KIRKLEES METROPOLITAN COUNCIL INVESTMENT & REGENERATION SERVICE

DELEGATED DECISION TO DETERMINE PLANNING APPLICATIONS

Reference No:	2025/62/90939/W
Site Address:	46, Lightridge Road, Fixby, Huddersfield, HD2 2HL
Description:	Demolition of a detached garage and erection of detached garage with first floor above to create dwelling forming annex accommodation associated with 46, Lightridge Road, Fixby, Huddersfield, HD2 2HL
Recommending Officer:	Joanna Rednall

DECISION – CONDITIONAL FULL PERMISSION

Proposed Site Plan

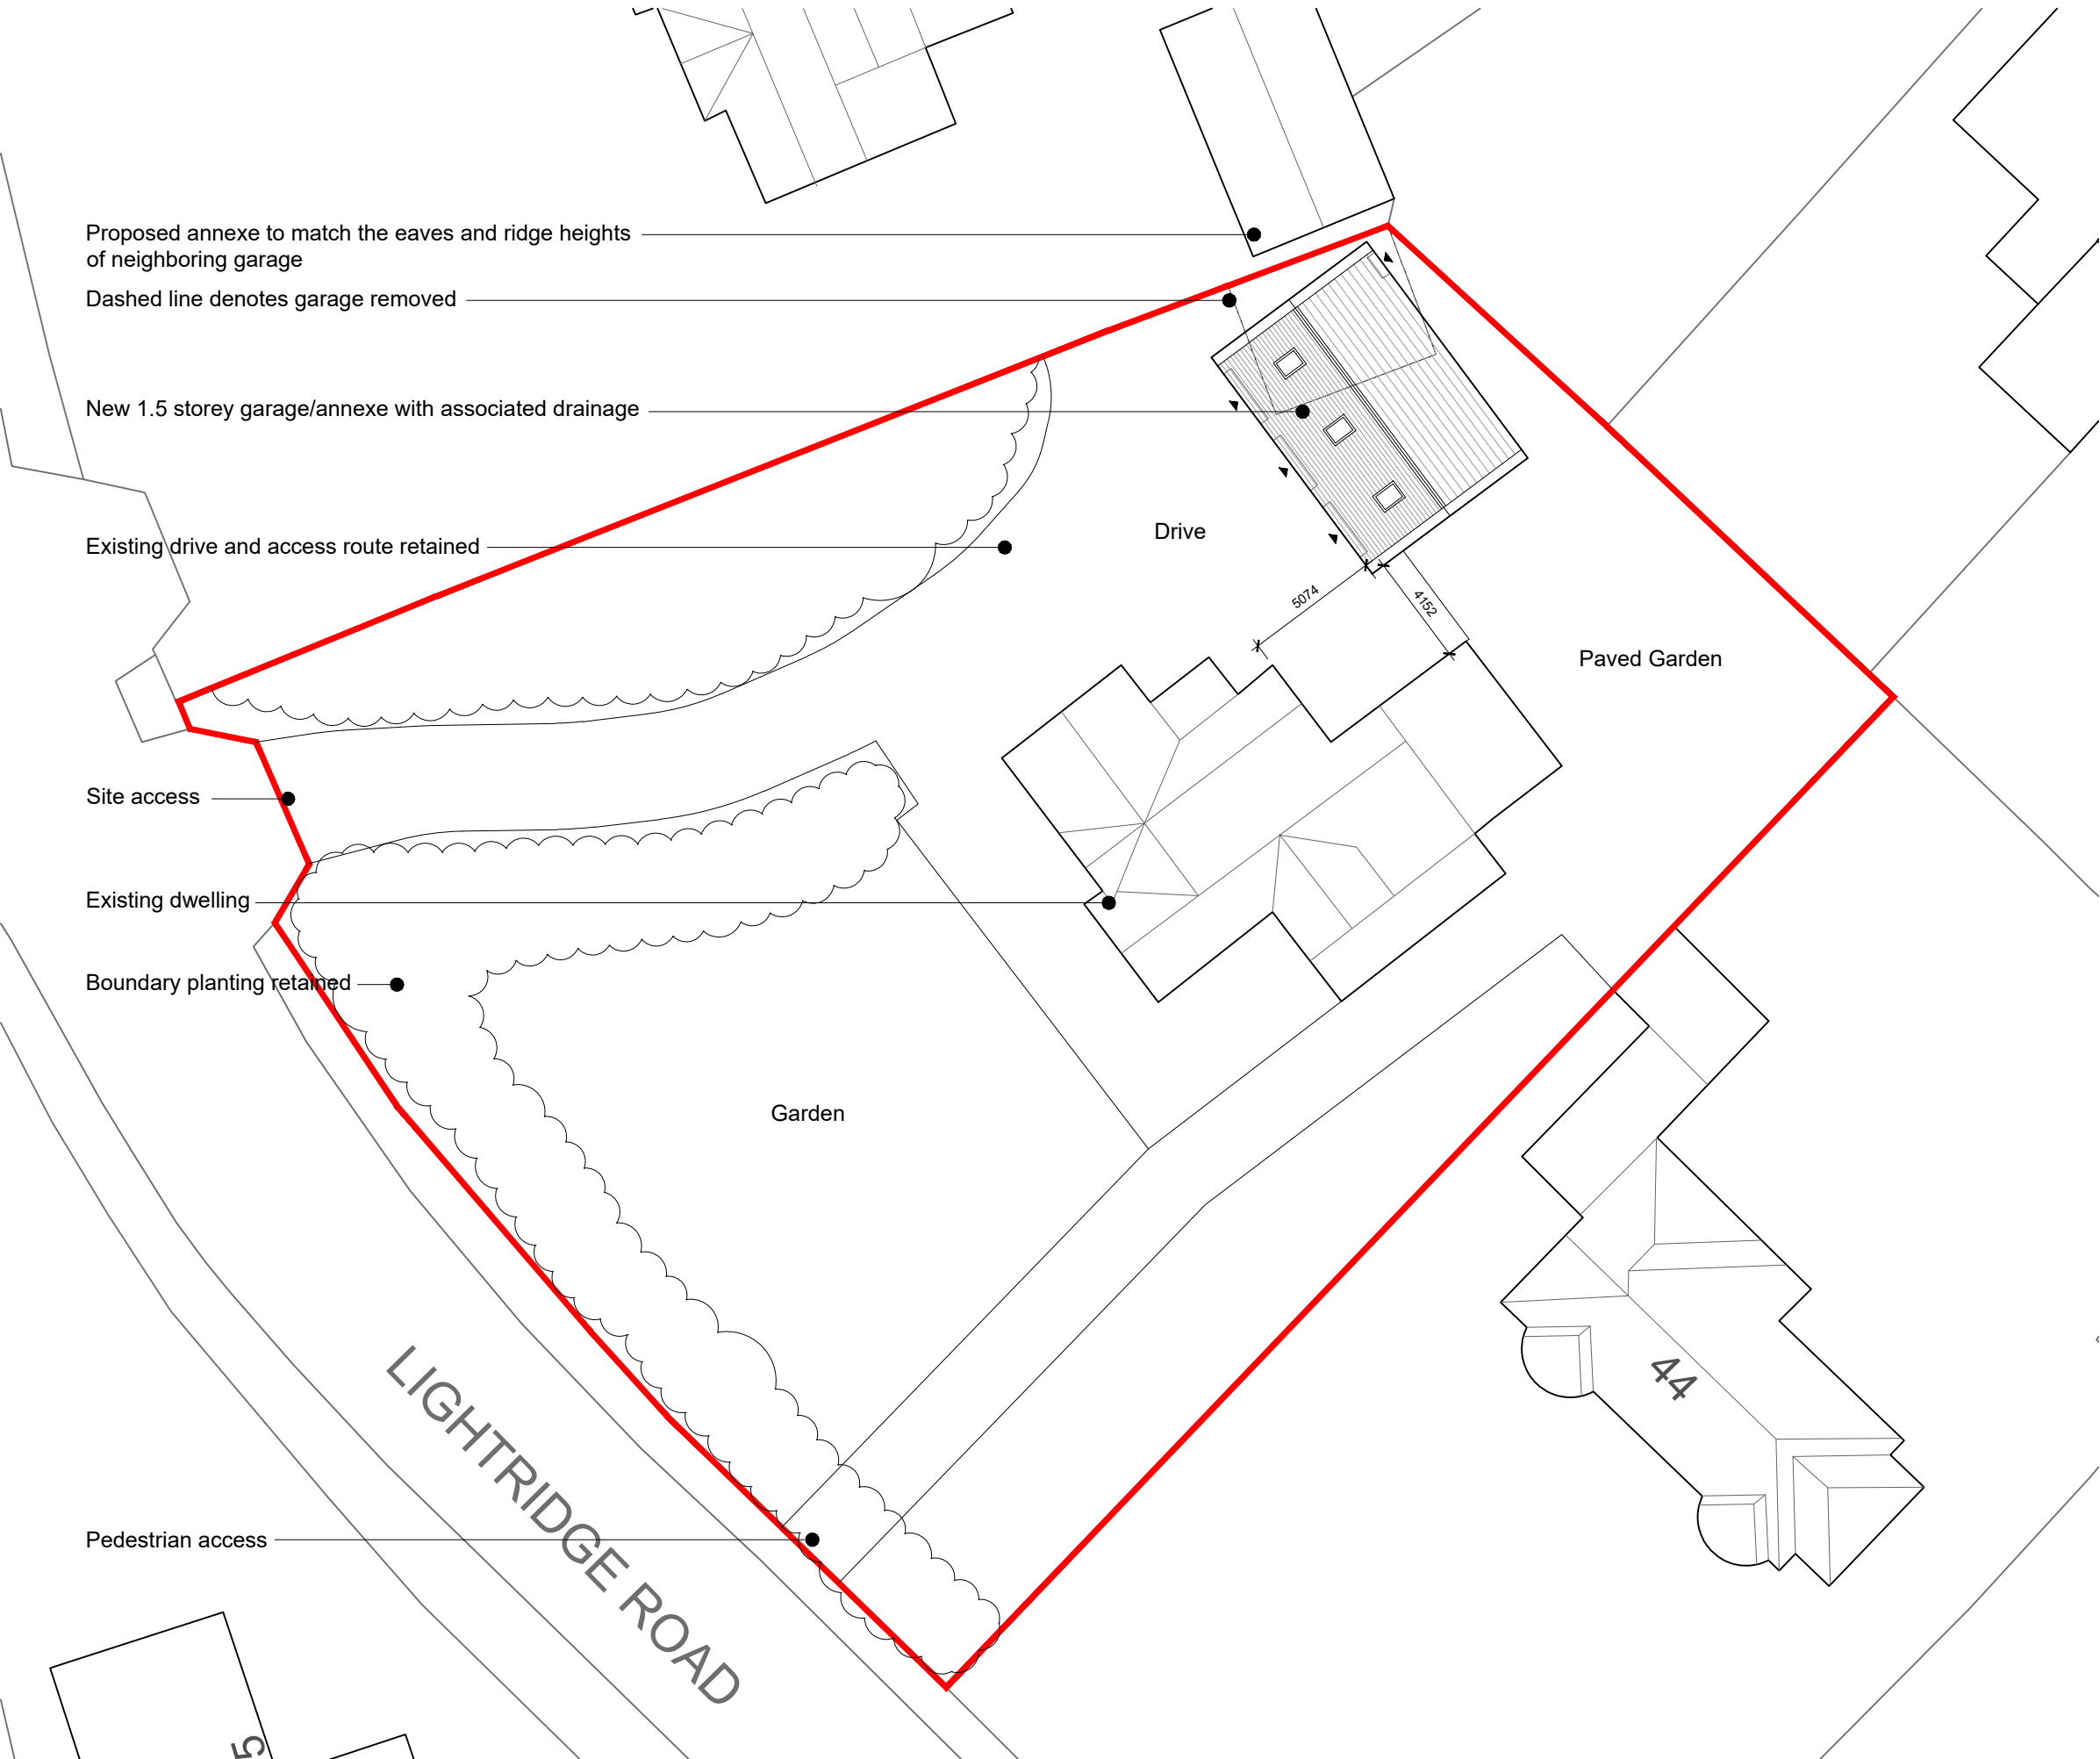
The outbuilding is located approximately 17.5m from the common boundary, and it is noted that the proposed Juliet balcony would face towards this neighbour.

proposed development would have an acceptable impact. The outbuilding maintains a separation distance of approximately 17.5 meters from the shared boundary with No. 44, and an even greater distance of around 25 meters to the side elevation of the neighbouring property itself. This spatial separation ensures that there would be significant overlooking or loss of privacy for the occupants of No. 44. Given this relationship between the properties, the proposed development is therefore not considered to unduly harm the privacy or overall amenity of the neighbouring occupiers.

The outbuilding features a blank rear elevation facing the neighbouring properties. However, to protect the amenity of these neighbours and prevent any potential harmful overlooking, officers consider it reasonable to impose a condition withdrawing permitted development rights for the insertion of any openings on the rear (north-east facing) elevation.

The proposed development would provide two parking spaces within the garage and would retain the whole driveway to the front of the dwelling. This is considered an appropriate level of off-street parking provision to serve the host dwelling and the addition of the annex accommodation. It is considered that whilst the works to the vehicular access / parking areas is considered acceptable, it is appropriate to ensure that surface water drainage is drained to a permeable part of the site or the surfacing is permeable. A condition to ensure this is the case is therefore recommended to be included upon any grant of permission.

6. Notwithstanding the provisions of The Town and Country Planning (General Permitted Development) Order 2015 (as amended) (or any Order revoking or re-enacting that Order) no doors, windows or any other openings shall be created in the northeastern (rear) elevation of the outbuilding hereby approved.
